Final Report - Corrections Required **Application No. ANEX-24-0002**

Description : Matrix Design Group on behalf of Colorado Springs Equities LLC is submitting a serial annexation petition for seven parcels and Land Use Plan/Rezoning exhibit for a portion of the subdivision known as Rock Creek Mesa.

Document Filename : 224.023-LEGAL-RCM ANNEX 2.pdf

ANNEXATION PLAT
ROCK CREEK MESA ADDITION NO. 2
LOCATED IN SECTION 30, TOWNSHIP 15 SOUTH, RANGE 66 WEST OF THE 6TH P.M.,
COUNTY OF EL PASO, STATE OF COLORADO.

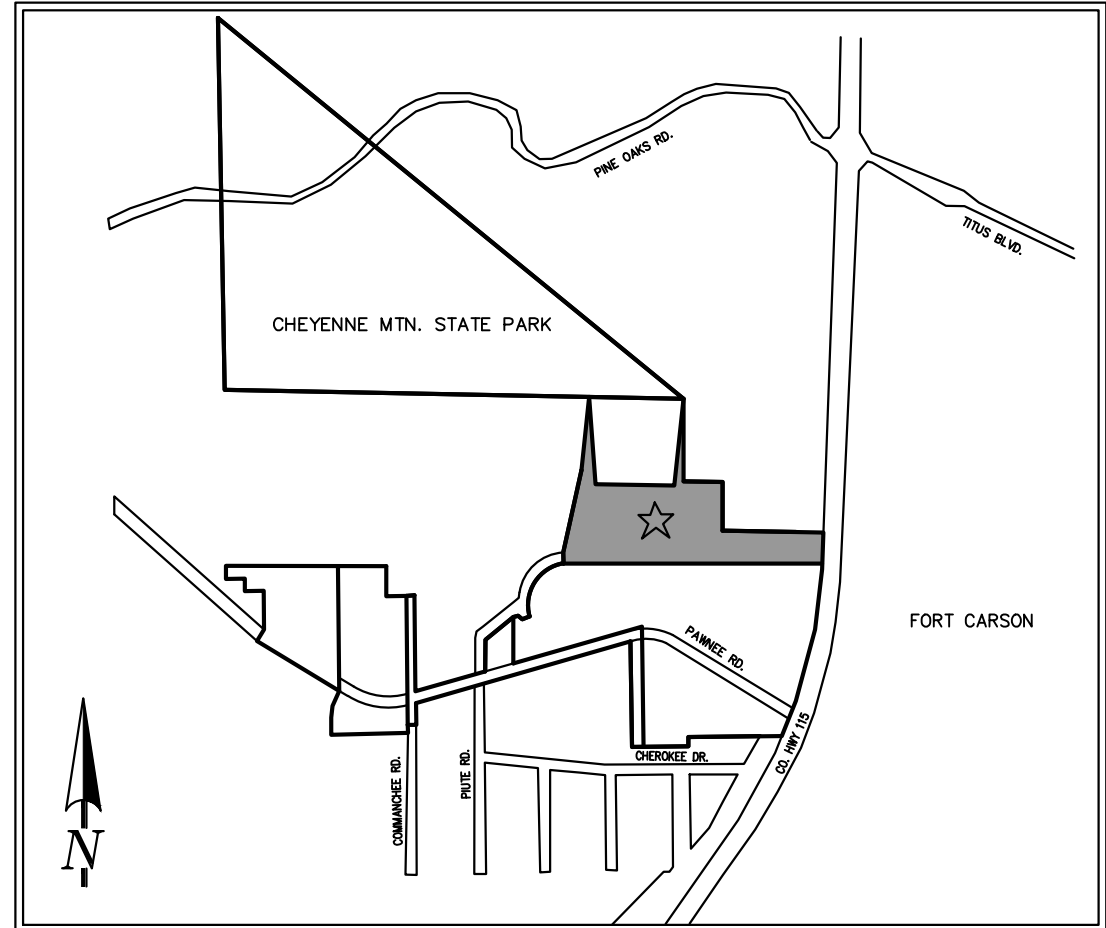
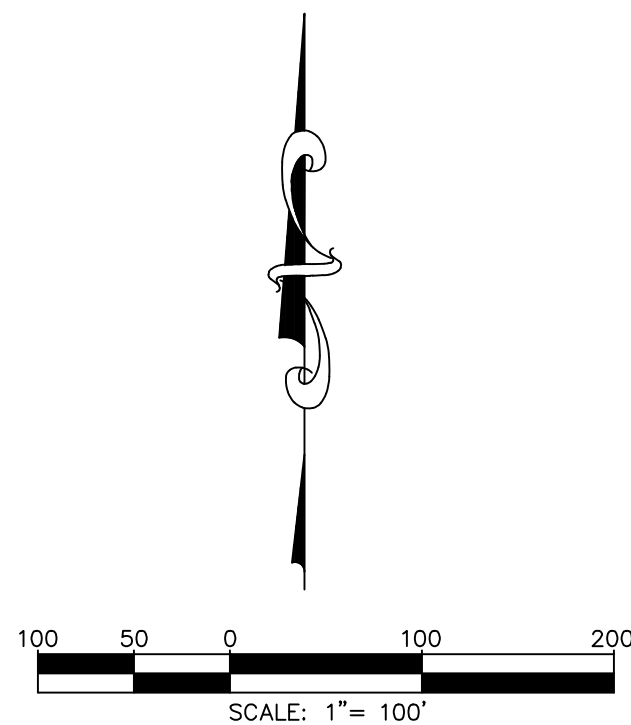
| Comment ID | Page Reference | Reviewer : Department | Review Comments |
|------------|----------------|-------------------------|--|
| 23 | 1 | Cory Sharp : Planning | Please add the area at the end of the legal description |
| 24 | 1 | Cory Sharp : Planning | Please revise exhibit A to: Legal description: Rock Creek Mesa Addition No. 2 |
| 26 | 1 | Gabe Sevigny : Planning | Any comments that are also on the annexation plat should be updated here, and vice versa |
| 27 | 1 | Gabe Sevigny : Planning | Add File Number |
